Consultation Response from KC, Lead Local Flood Authority
2023/93388 Dene End Funeral Home, 50, North Road, Kirkburton, Huddersfield, HD8 0RW
Change of use from domestic to commercial, demolition of existing workshop and erection of three storey office building (within a Conservation Area)
Date Responded: 20 th May 2024 Responding Officer: Paul Farndale Responding Ref:

Kirklees Flood Management and Drainage maintains its OBJECTION to this development.

DRAWING TITLE
LOWER GROUND FLOOR PLAN - PROPOSED

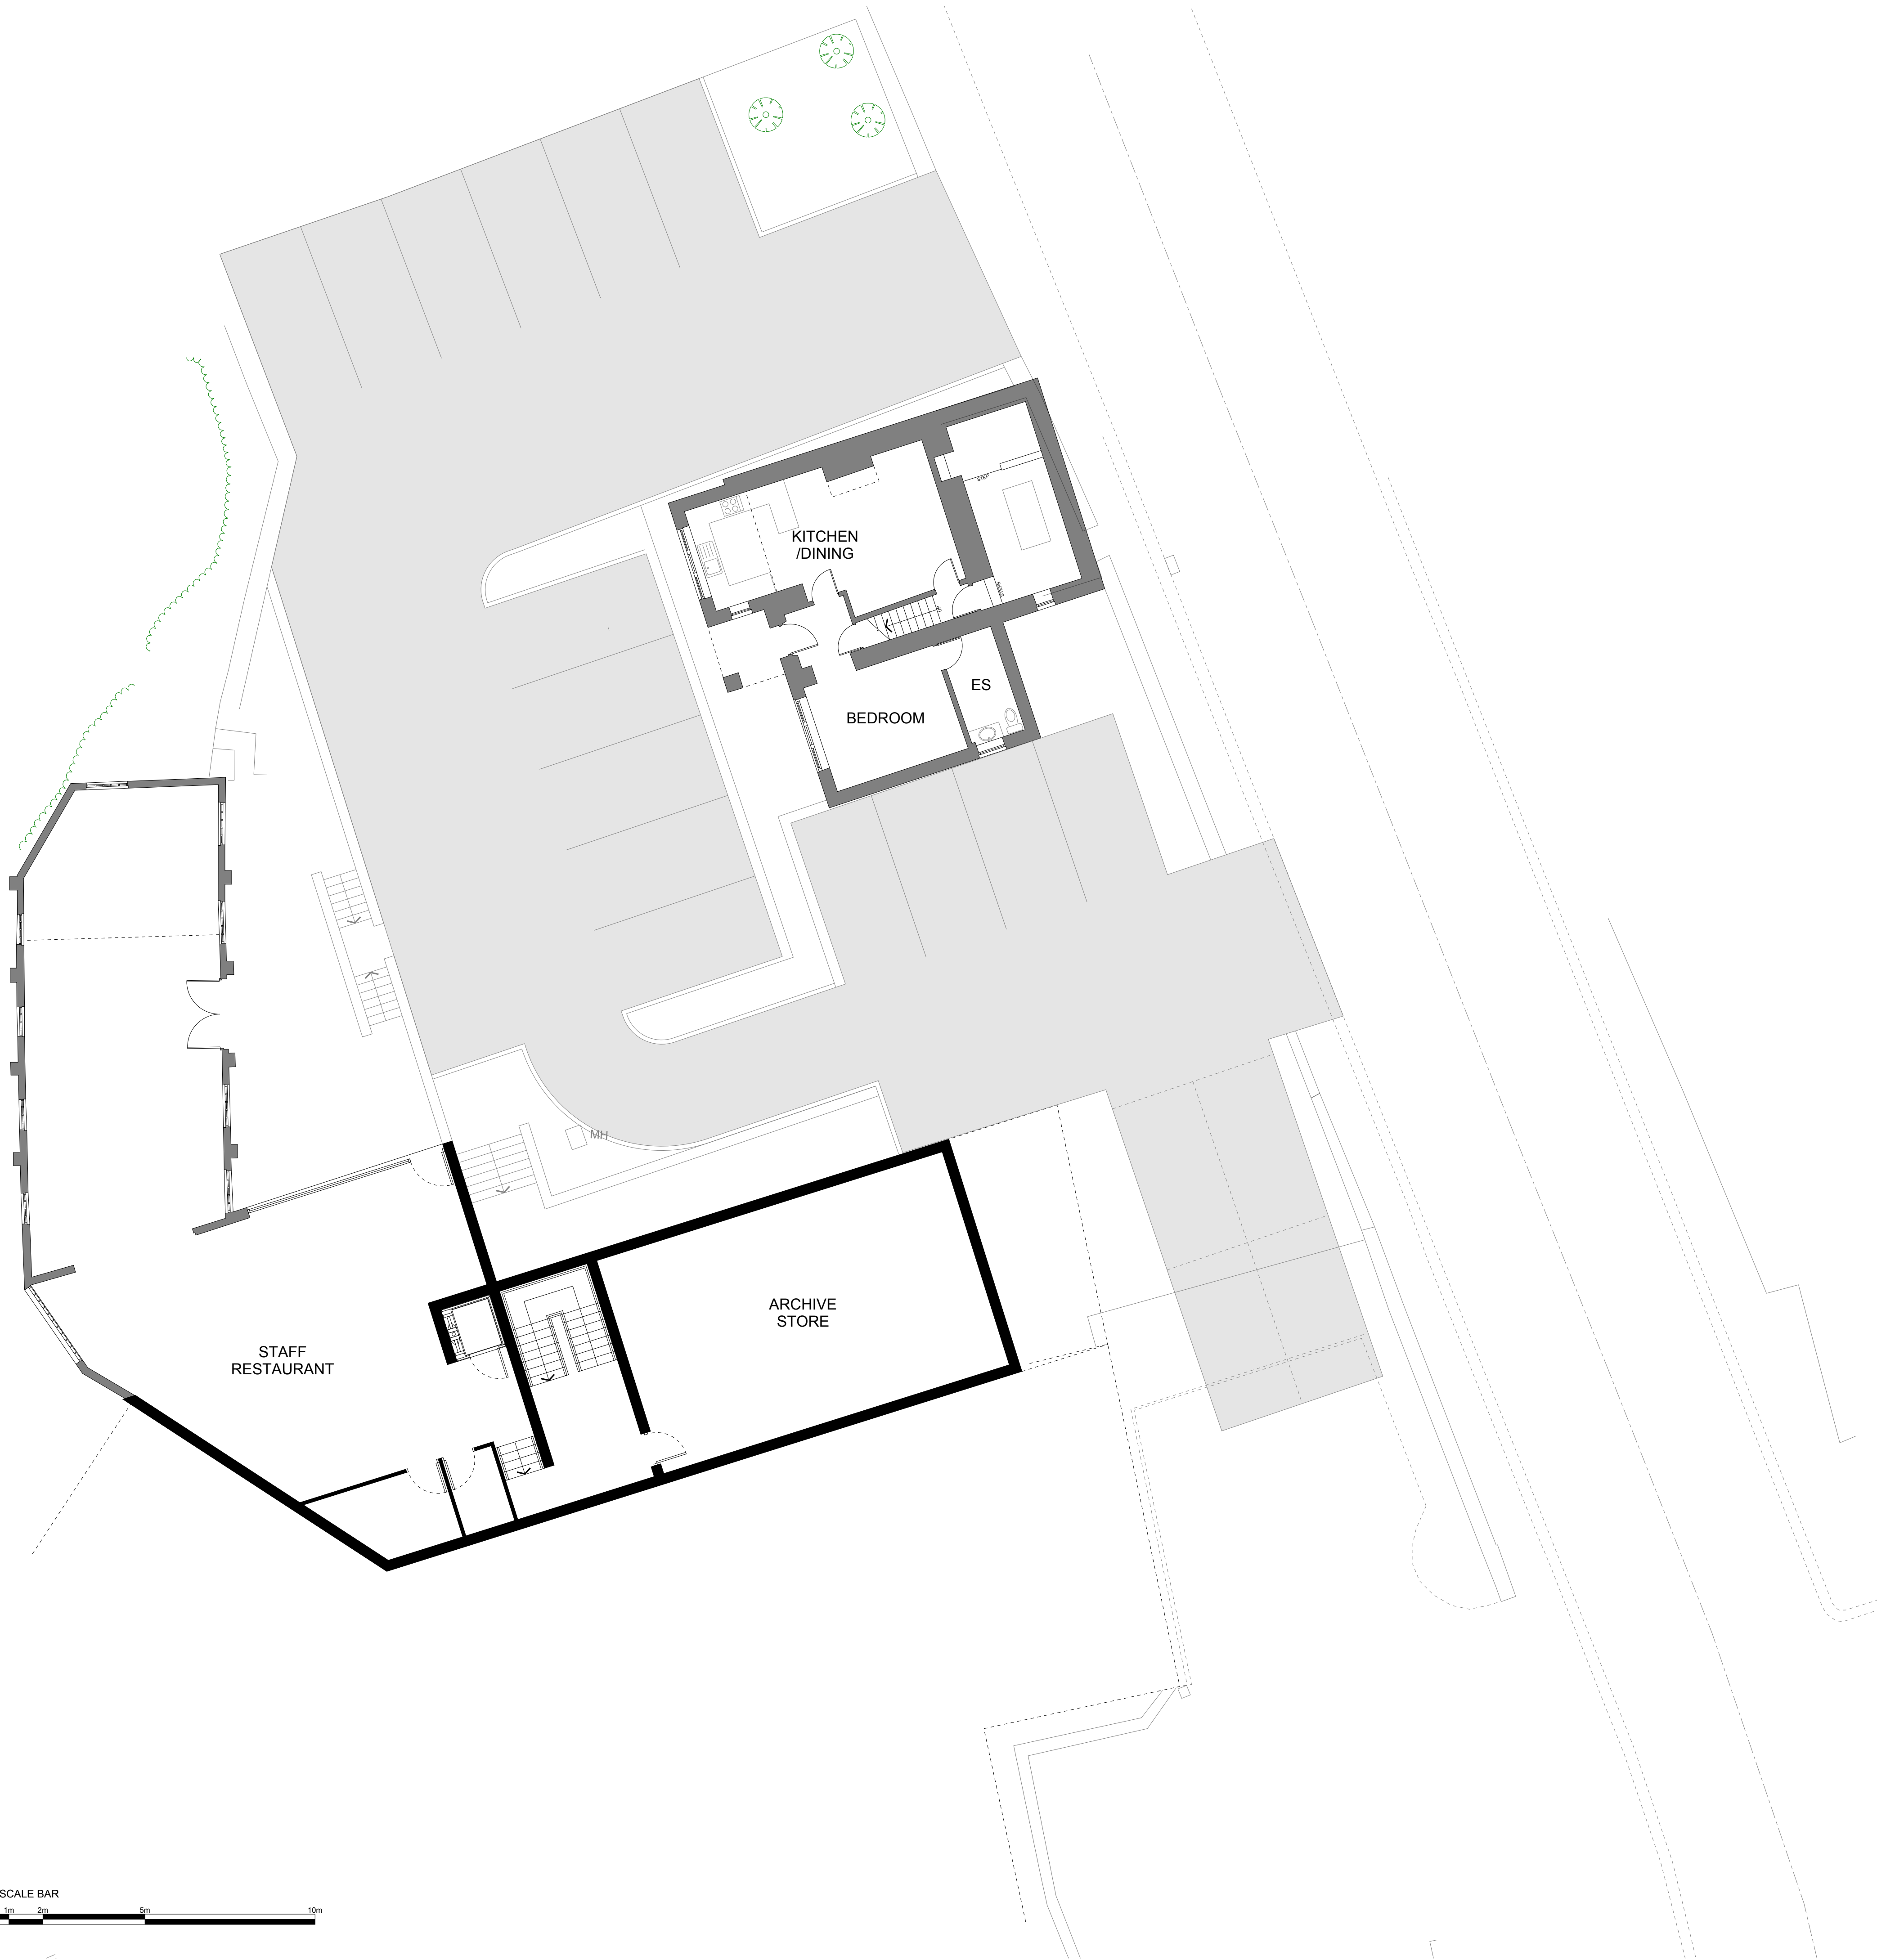
Clarification is required over the application title 'change of use' from 'domestic to commercial', where all proposed plans show a 3-level domestic dwelling included the lower ground floor, shown to flood previously.
